Planning Application Ref: FG/47/20/T

Location: Corner of Everlands Road and Alderney Road, Ferring, BN12 5PW

Description of works: Removal of 2 low hanging branches from 1no. Monterey pine tree

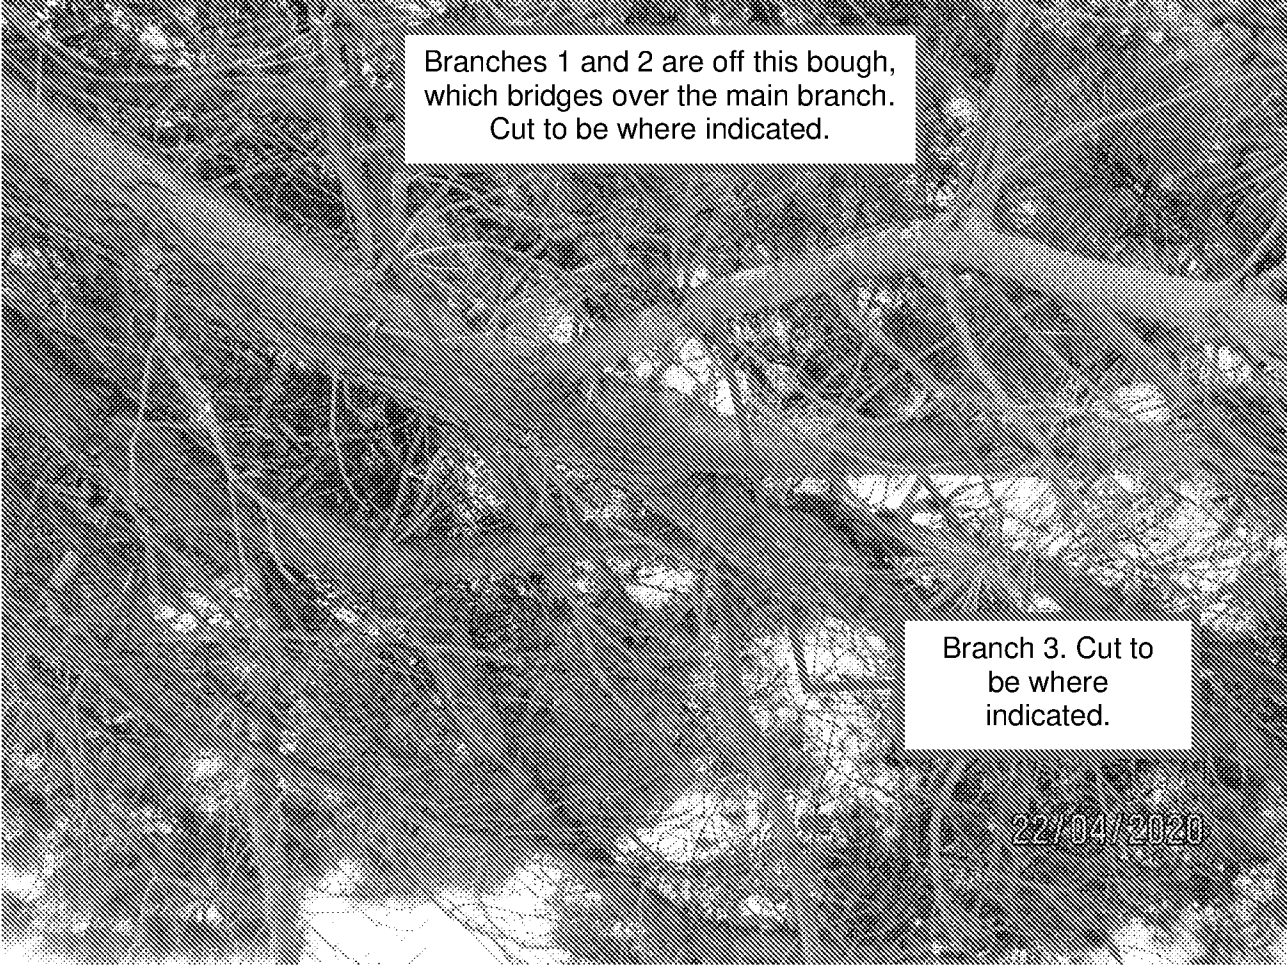
Monterey pine / *Pinus radiata* Approx. height: 8m Average spread: 4m Age class: Early mature

- This tree appears to be outwardly healthy and stable with a relatively unmodified and attractive crown profile.
- It grows from roadside verge appearing to be outside the curtilage of adjacent dwellings and is a prominent (landmark) tree on the estate. As such, it has high public amenity value.
- The application is supported by a detailed work specification, which proposes the removal of carefully selected branches that are either undergoing natural decline (shading) or with potential to encroach into the carriageway.

- Part a) Where whole branches are to be removed and final cuts made close to the trunk or branch union they are to be made as shown in Figure 2 of BS3998:2010
- Part b) Where branches are to be shortened back the final cuts are to be made at the correct angle shown in BS3998:2010 and adjacent to a live bud or lateral.
